WEST SUSSEX COUNTY COUNCIL CONSULTATION

TO:	Arun District Council FAO: James Cross
FROM:	Stephen Gee WSCC - Highways Authority
DATE:	21 January 2021
LOCATION:	Warwick Nursery Barnham Road Eastergate Barnham PO20 3RT
SUBJECT:	BN/153/20/PL 44 No. dwellings & associated infrastructure. This site falls within the BEW Strategic Site, CIL Zone 1 (Zero Rated).
DATE OF SITE VISIT:	n/a
RECOMMENDATION:	Objection / More Information
S106 CONTRIBUTION TOTAL:	TBC

Figure 5.1 – Public Rights of Way (WSCC PRoW)

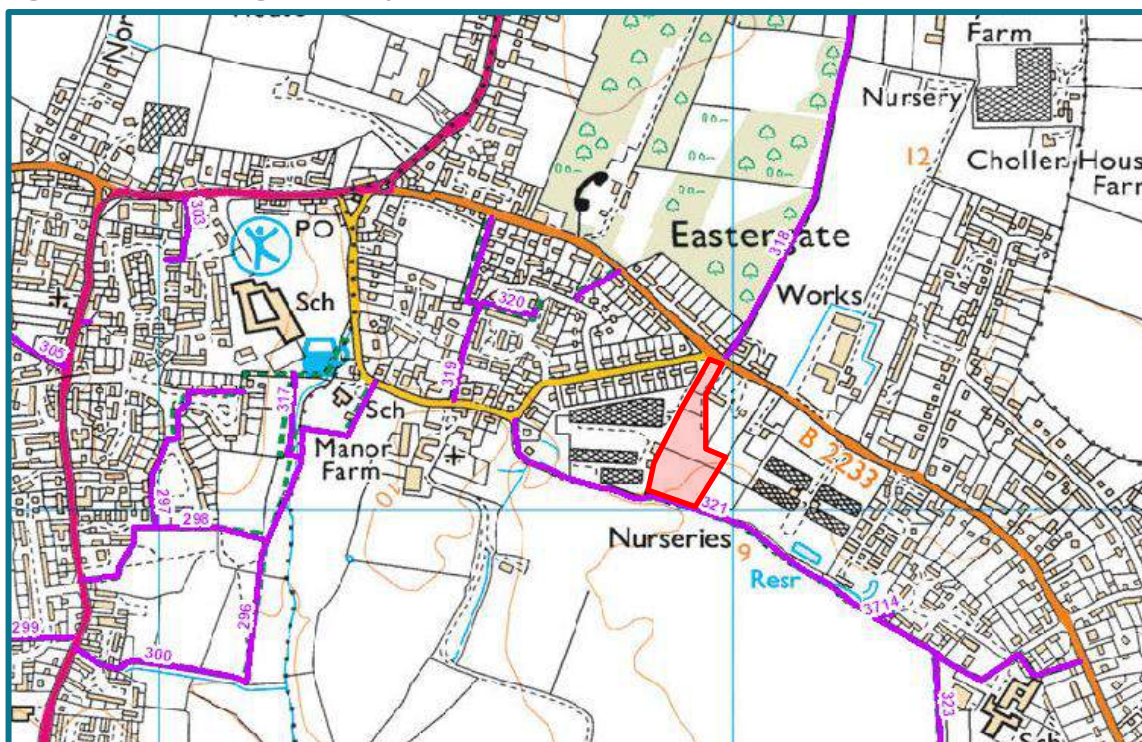
The site access is adjacent to PROW 318. Details should be provided to indicate how future residents would cross Barnham Road and access the PROW (and indeed the footway provision required to access Barnham station)

No connections from this site are shown onto PROW 321 which would provide access to a route to Barnham station which is to be upgraded in the future, instead the masterplan relies on connections from within adjoining sites.

Access Drawing / Traffic Calming Measures / Visibility Splays

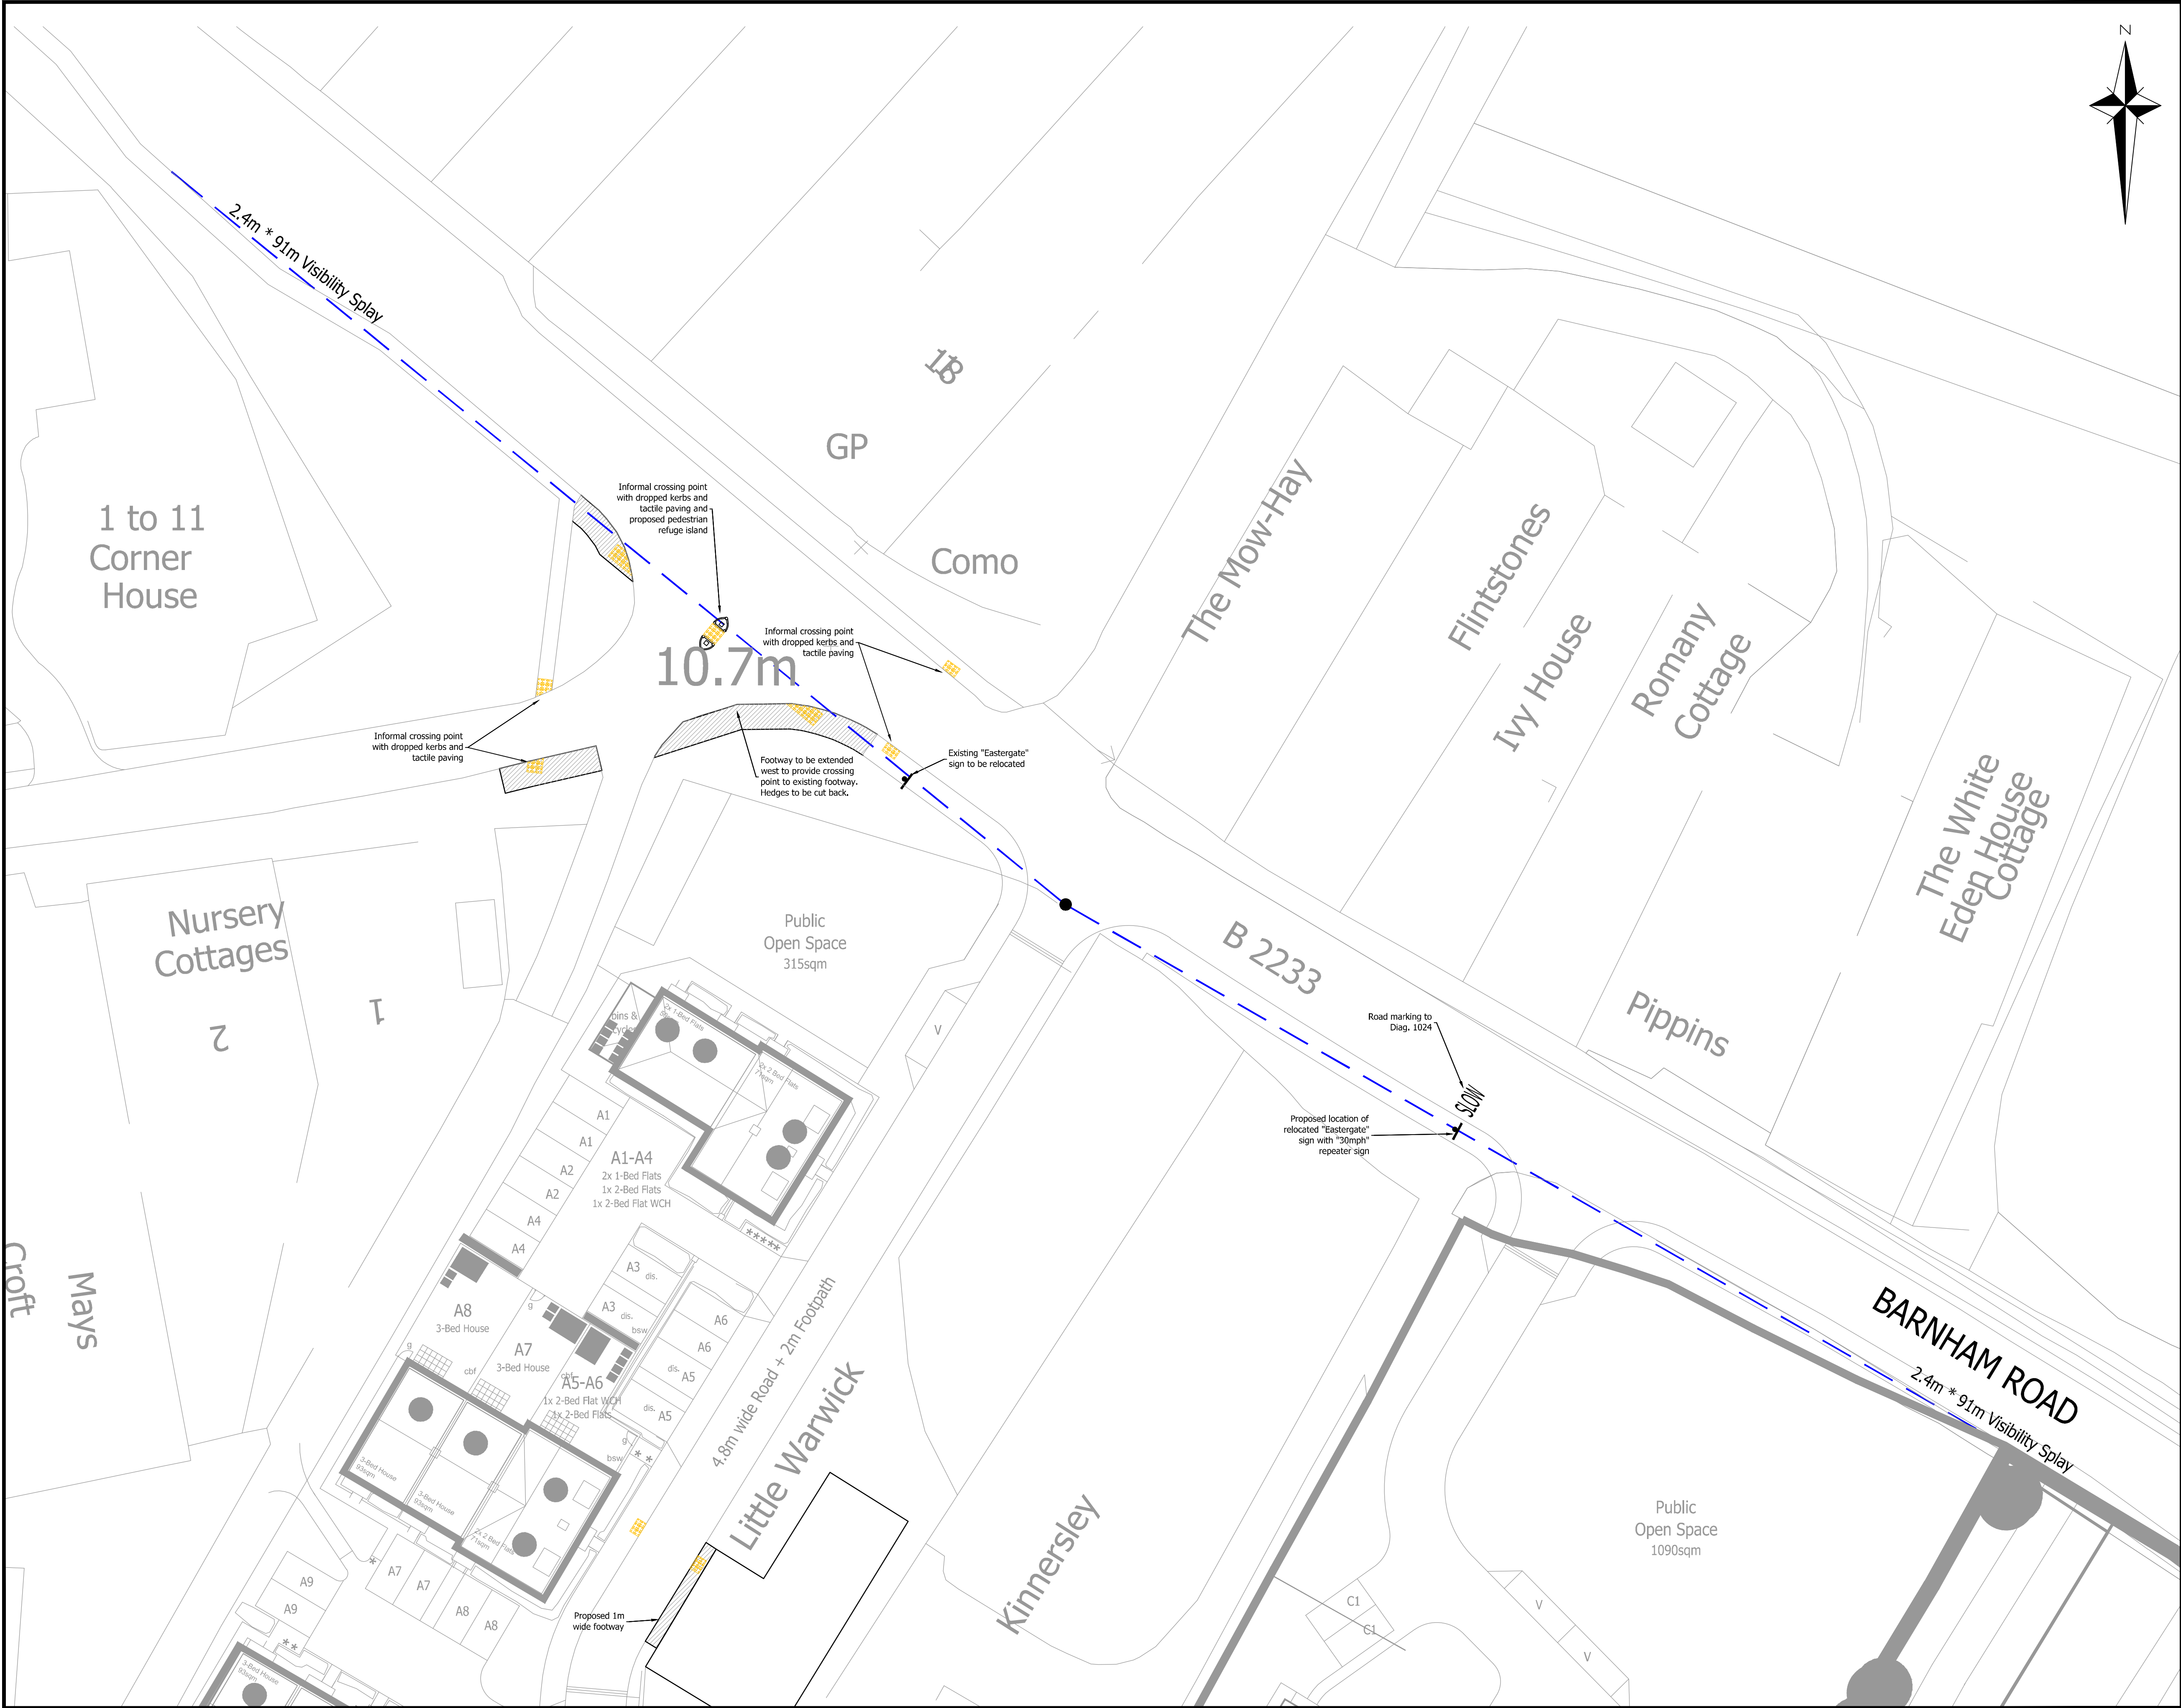
The site currently benefits from a shared access onto Barnham Road which would be upgraded to serve the development. Speed surveys undertaken in April 2019 identify 85th% speeds of 37mph and as such visibility splays of 2.4m x 91m should be provided in line with Manual for Streets requirements. The existing access is to be widened to 4.8m with a 2m footway on the western side. A 1m footway is proposed to the east of the access to provide access to Little Warwick. 1m is the absolute minimum width that a footway should be and only in exceptional circumstances, therefore it is recommended that the width is widened.

Vehicle tracking has been provided and shows a refuse vehicle would not only overrun the centre line but require the entire carriageway, further details are required to show inter-visibility between refuse vehicles turning into the site and any using the main spine road of the development.

A stage 1 RSA has been undertaken and identifies 3 issues, one of which is traffic calming. The applicant indicates the traffic calming would consist of slow markings, relocated sign (which is required to address visibility constraints and would negatively effect an existing access in the location identified) and a 30mph repeater sign which given the presence of street lighting a 30mph sign would not be required.

It is considered that the applicant identification would not constitute traffic calming and would not address the auditor's recommendation. The applicant should provide an appropriate scheme and develop it in line with WSCC traffic calming guidance

Drawing Title
Proposed Site Layout

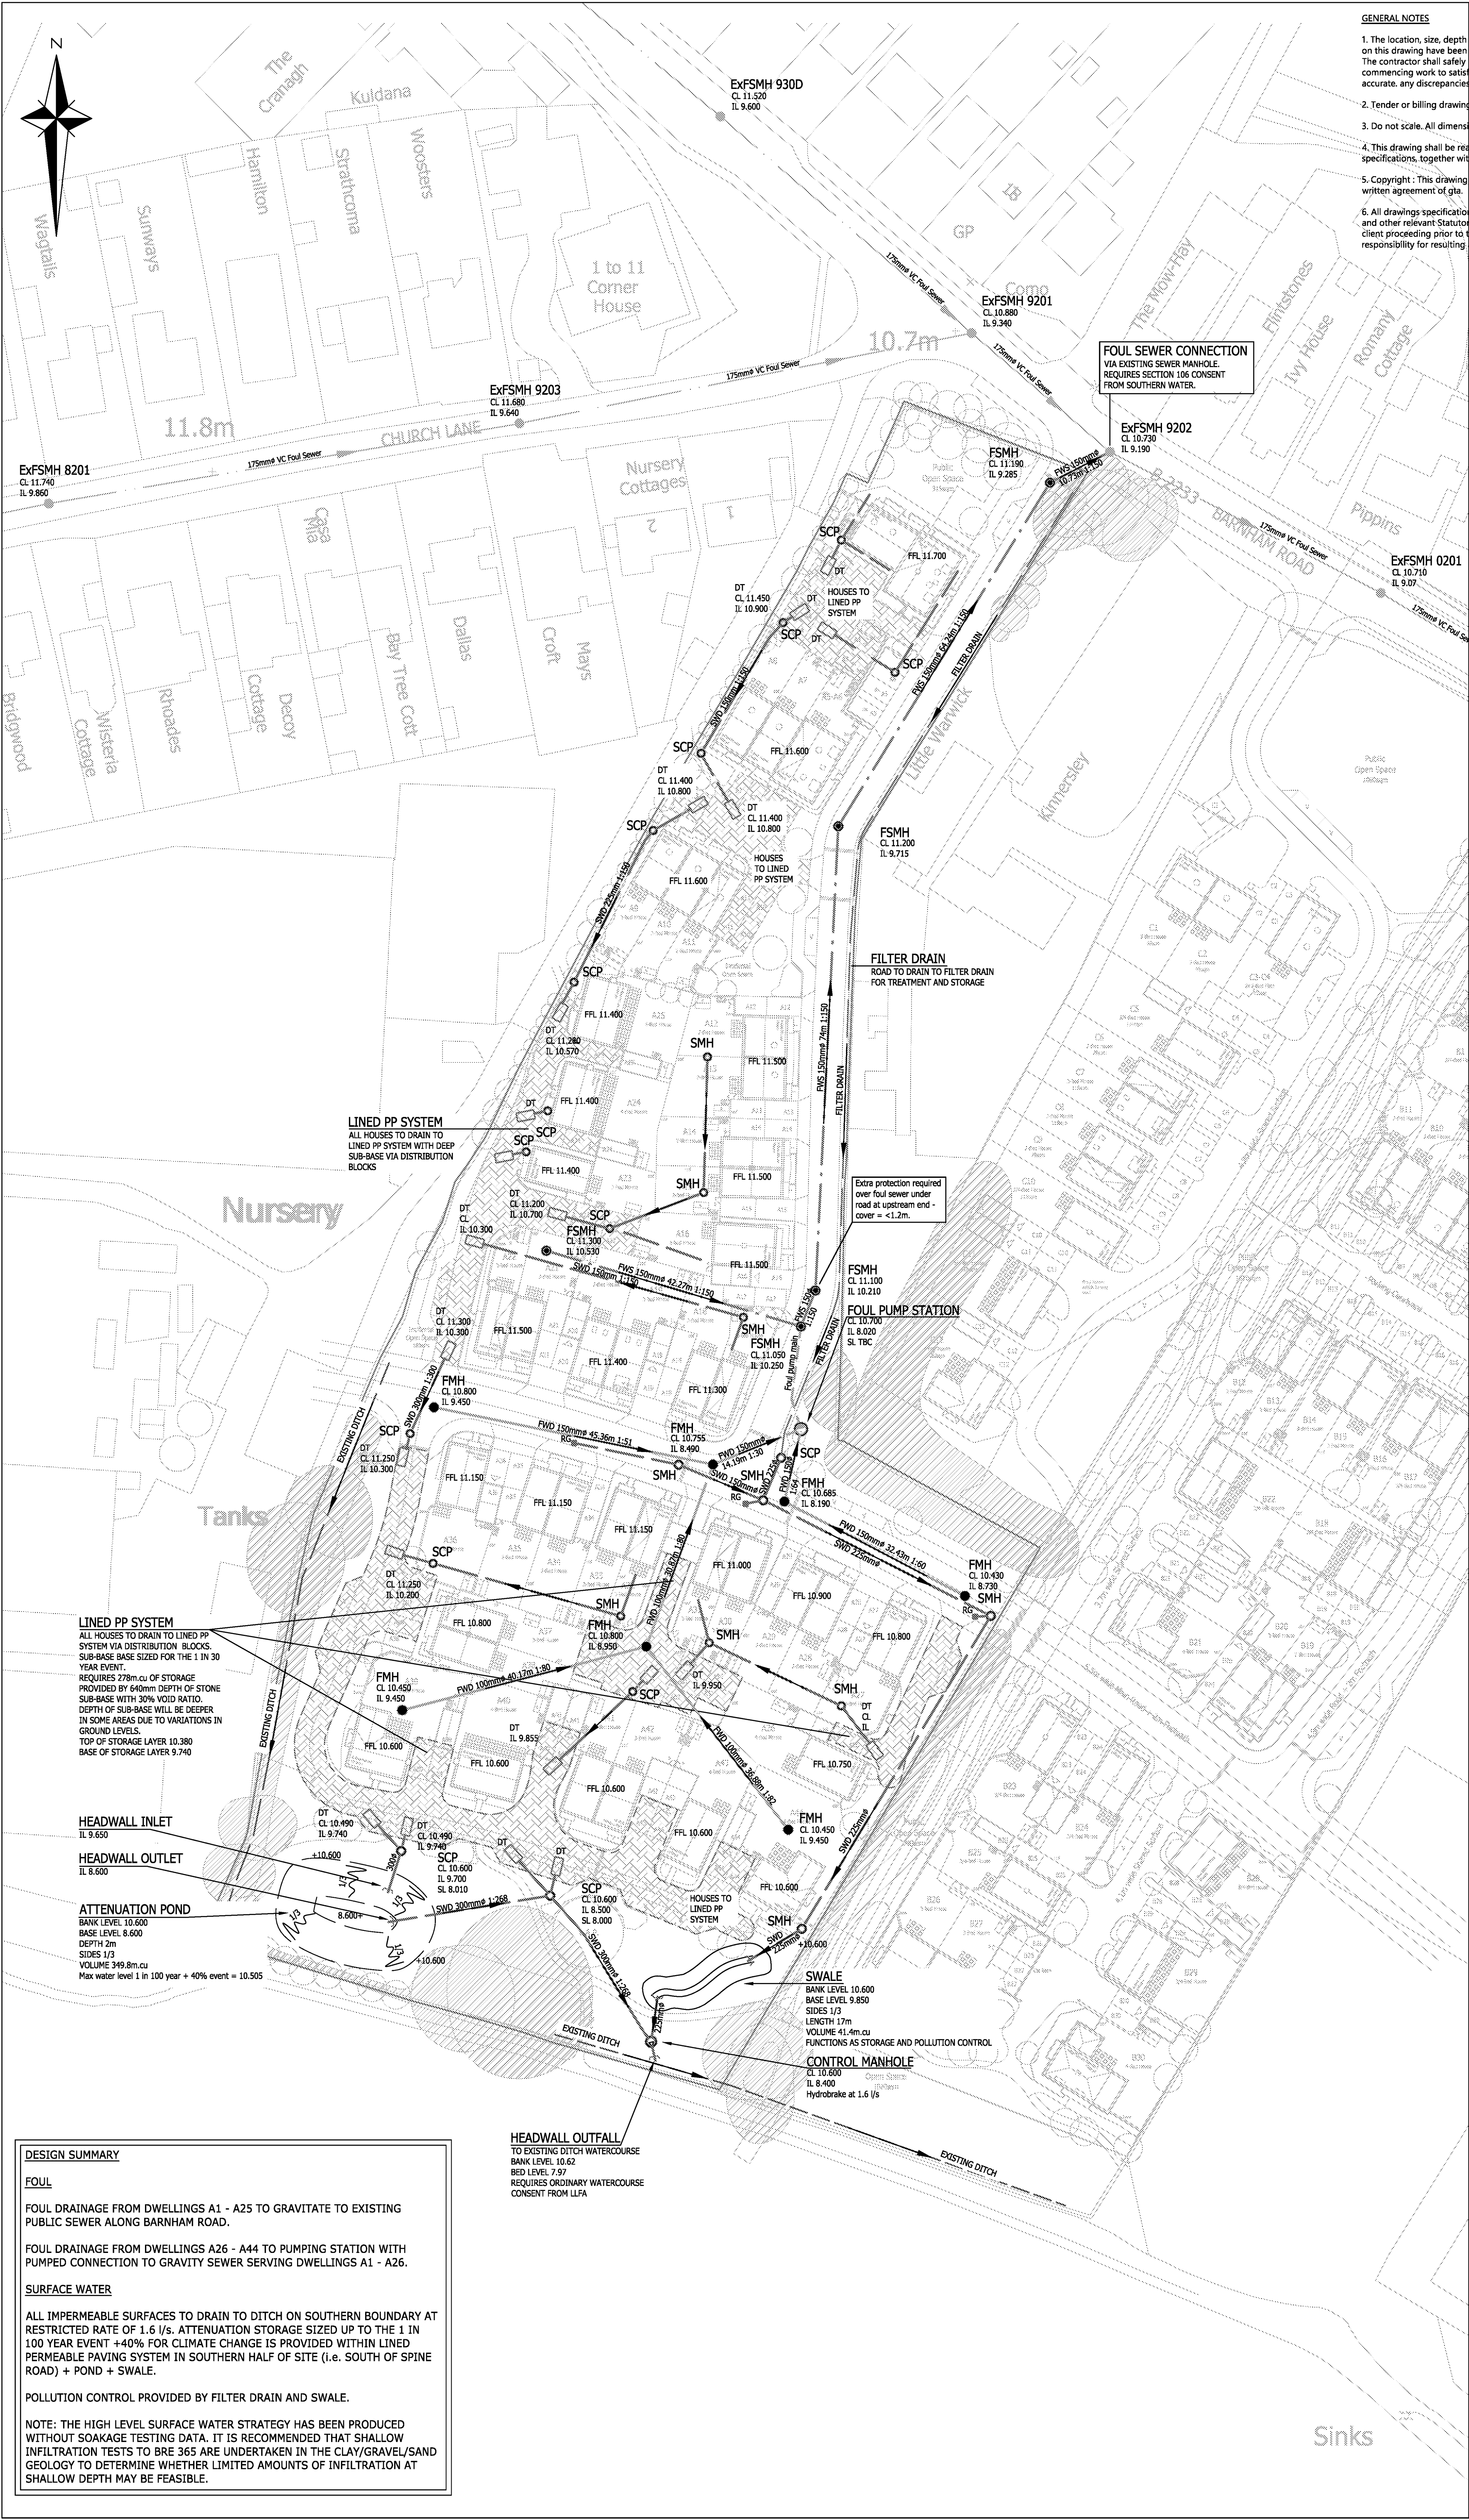
From the plans submitted it is unclear as to the extent of internal highway provision prior to any adjoining sites coming forward and as such concerns are raised about how large vehicles would manoeuvre within the site.

A total of 93 allocated and 14 visitor parking spaces are to be provided approximately 10% below the standard. The spread of visitor parking is very unbalanced across the site and should be reconfigured.
